County File: OAR-20-018

Re: Cottages at Woodman Heights – Rezone, PUD Development Plan

To: City of Colorado Springs (Cynthia.Hurst@coloradosprings.gov)

**PRELIMINARY  
LANDSCAPE PLAN**

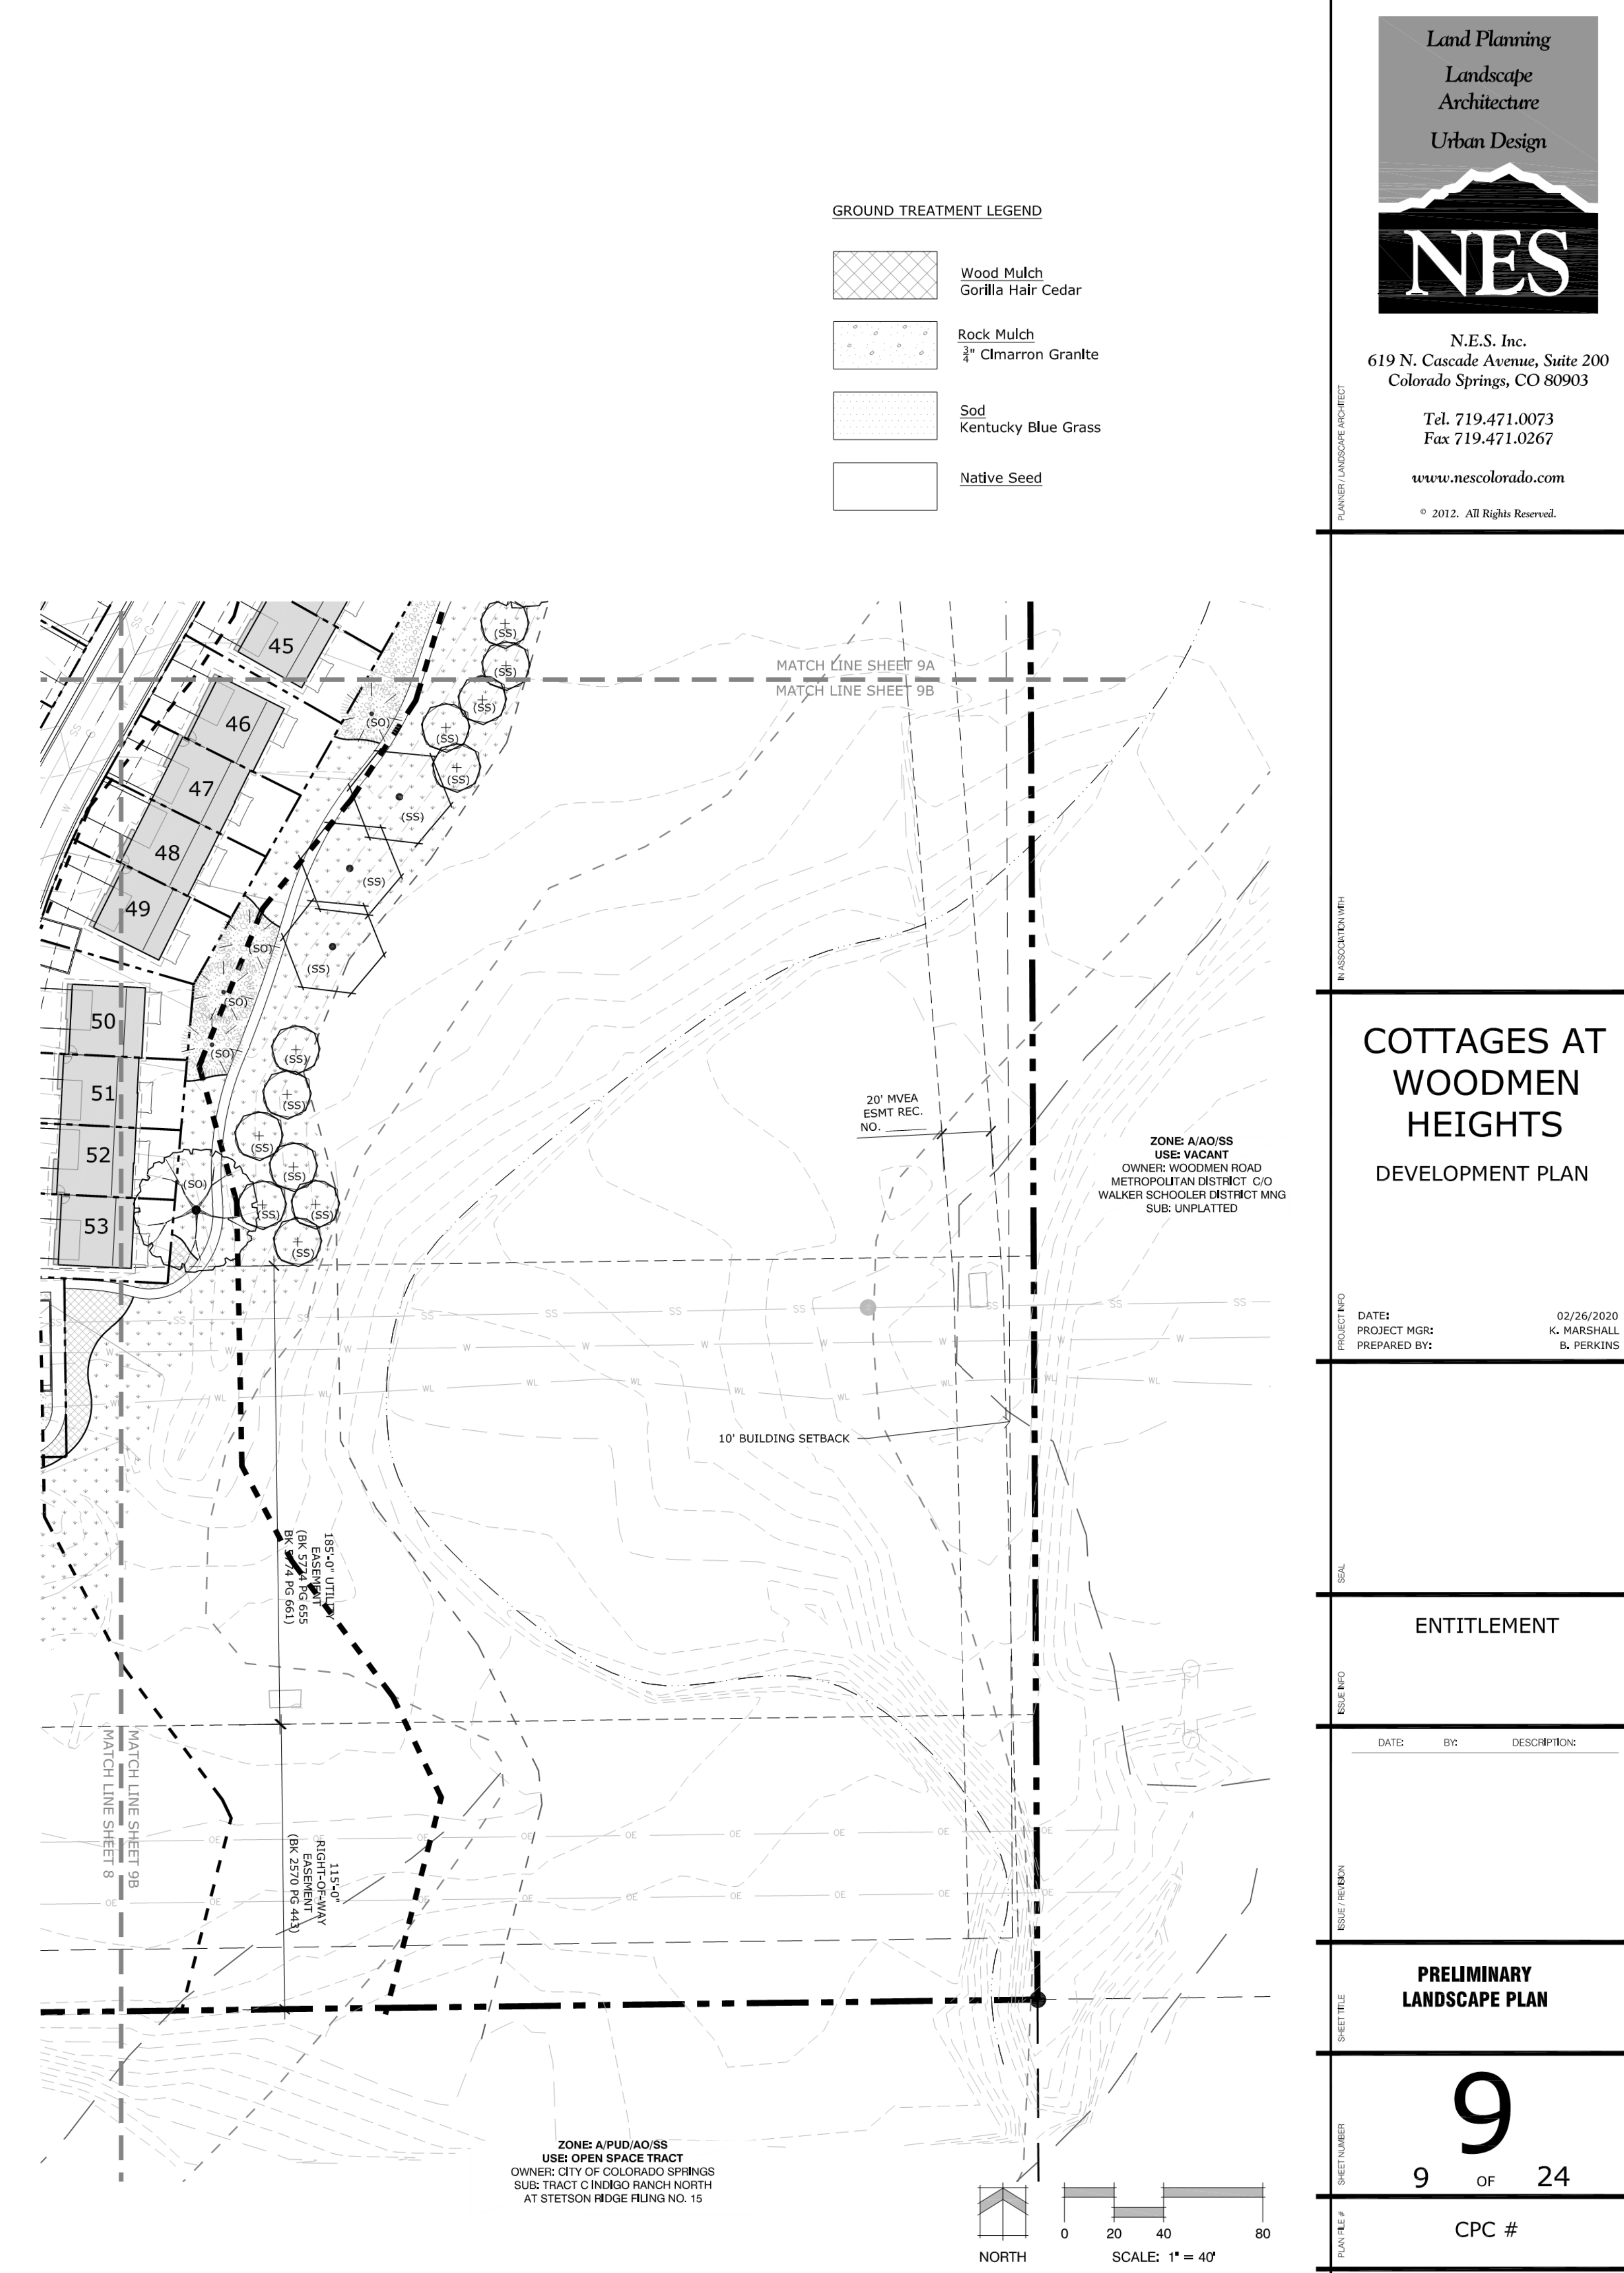
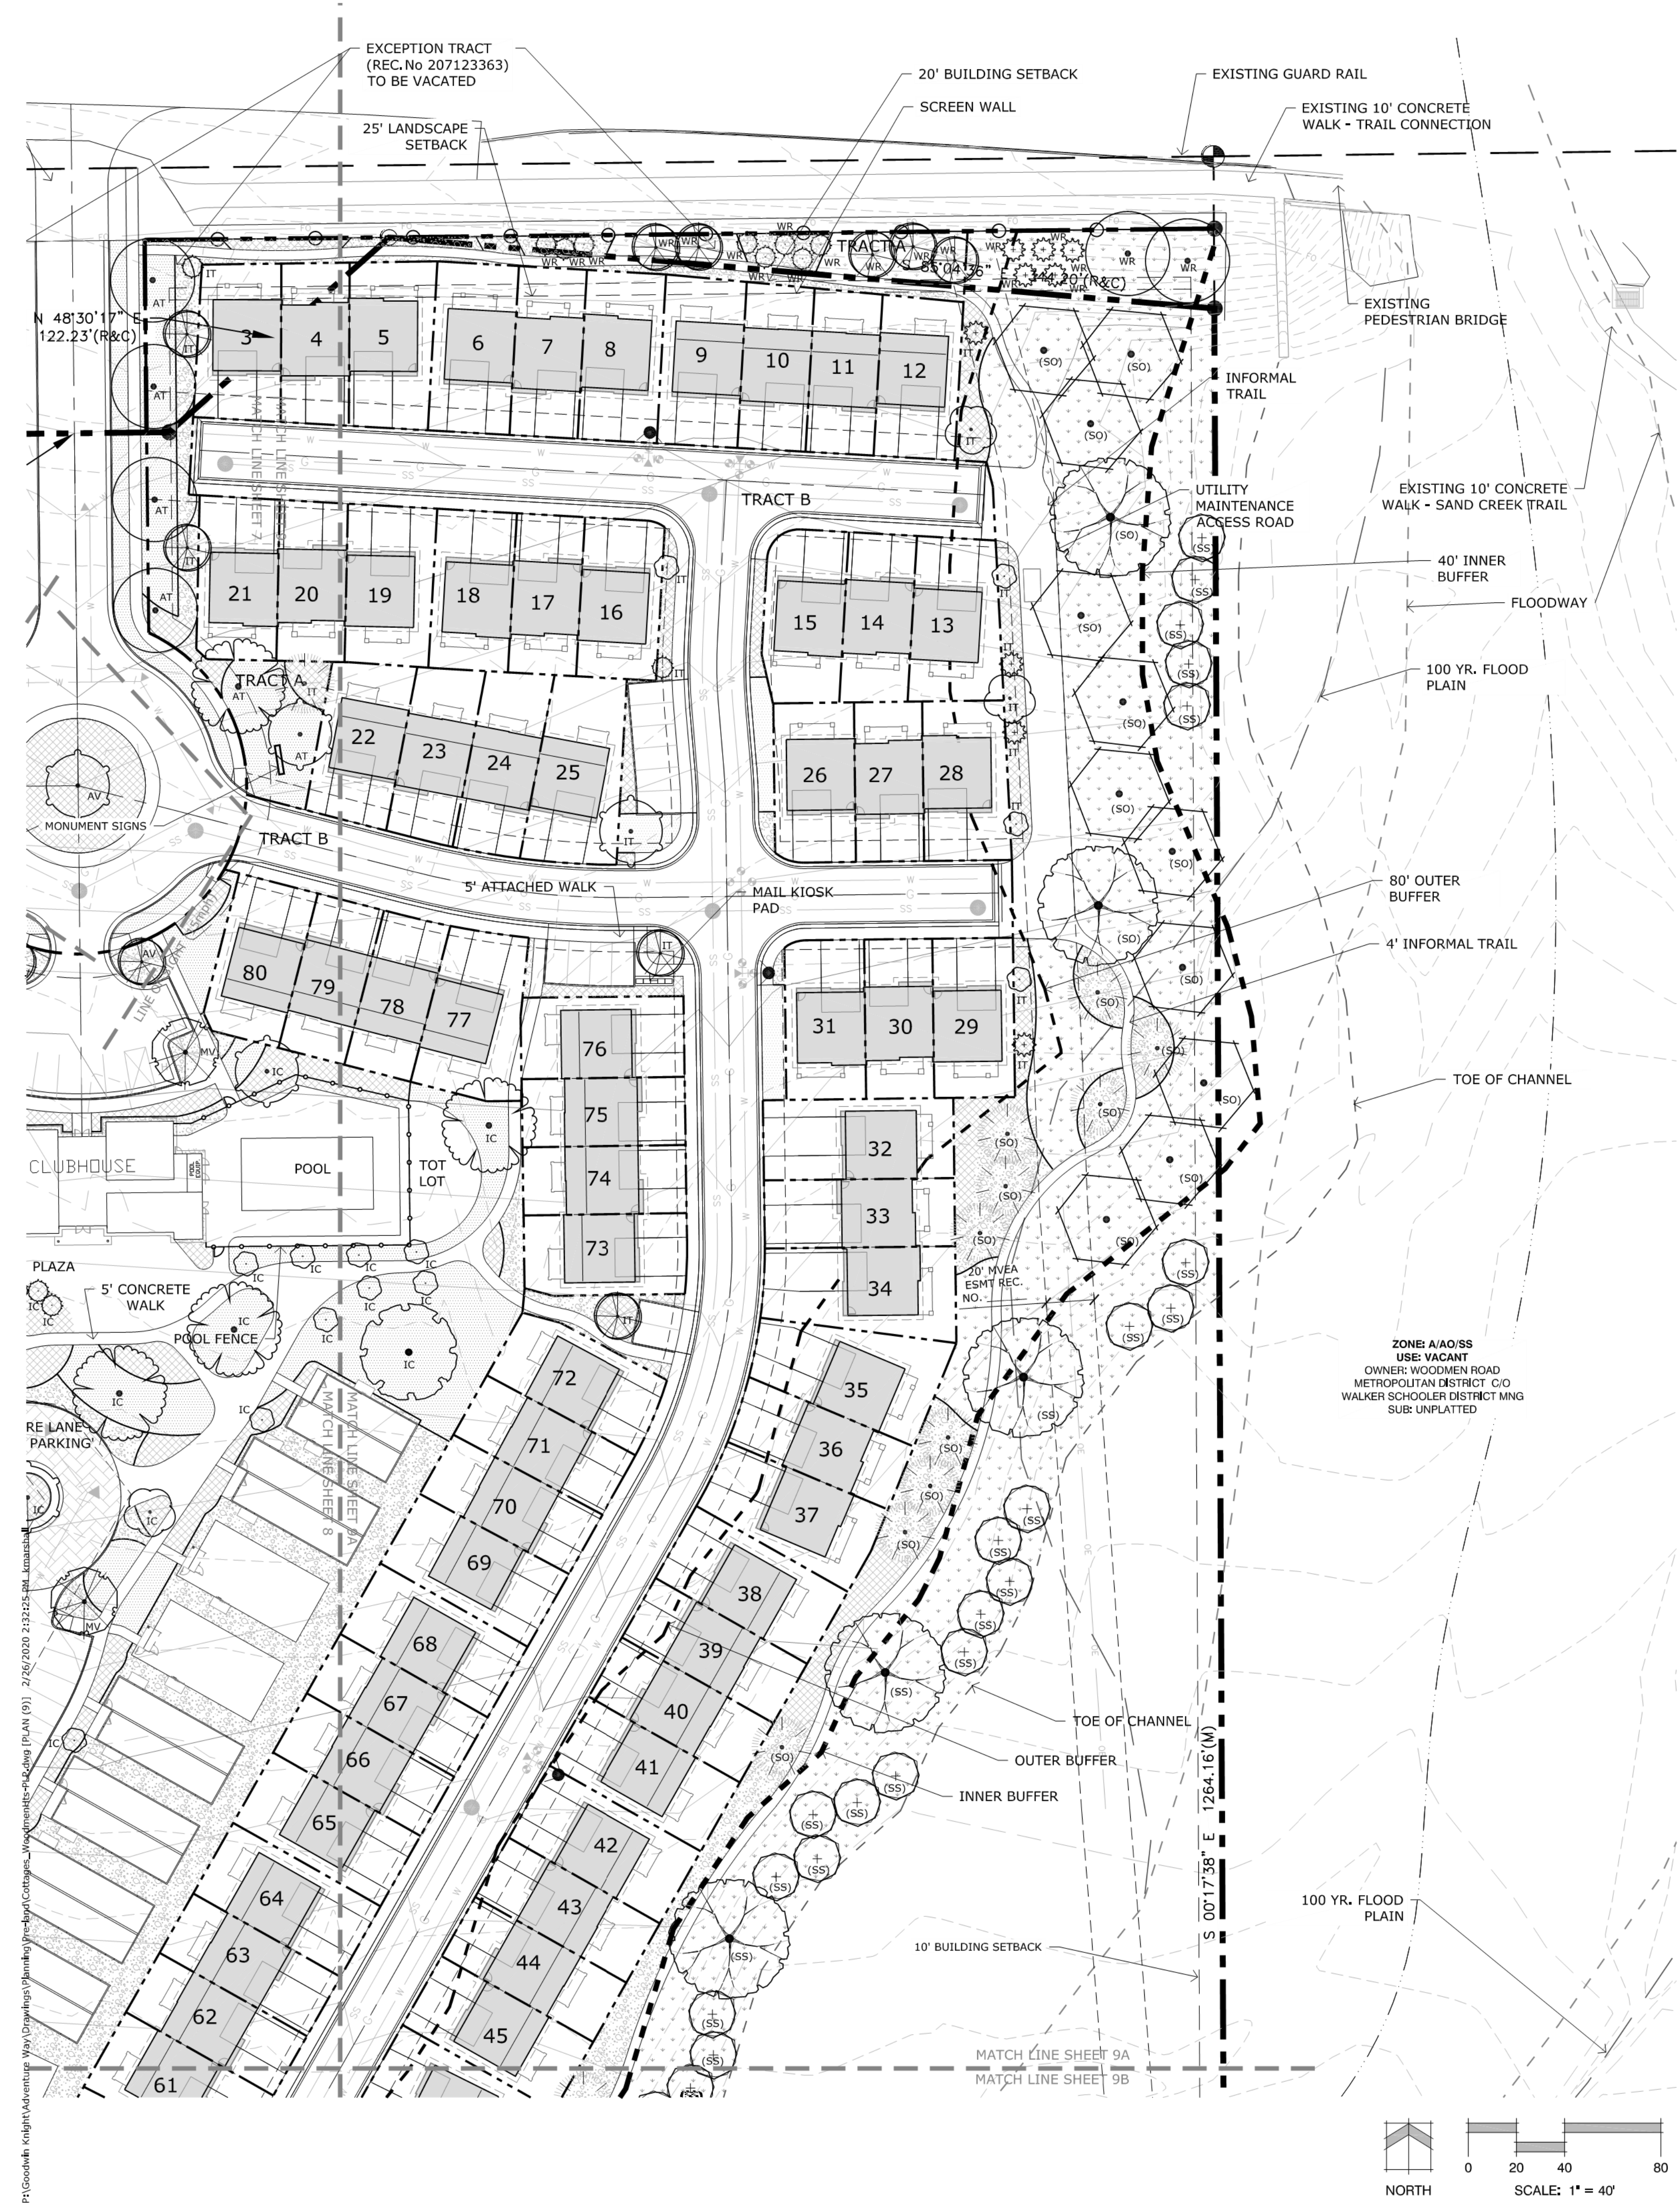
2. The landscaping plans provided do not show suitable buffering on the south side from multifamily zoning to adjacent county single-family RR-5 zoning. El Paso County LDC §6.2.2(D)(2) requires a 15-foot landscape buffer between single-family zoning district and multi-family use, with one tree for every 25 feet of common lot, parcel, or tract line, and a minimum of 1/3 of the trees being evergreen trees.
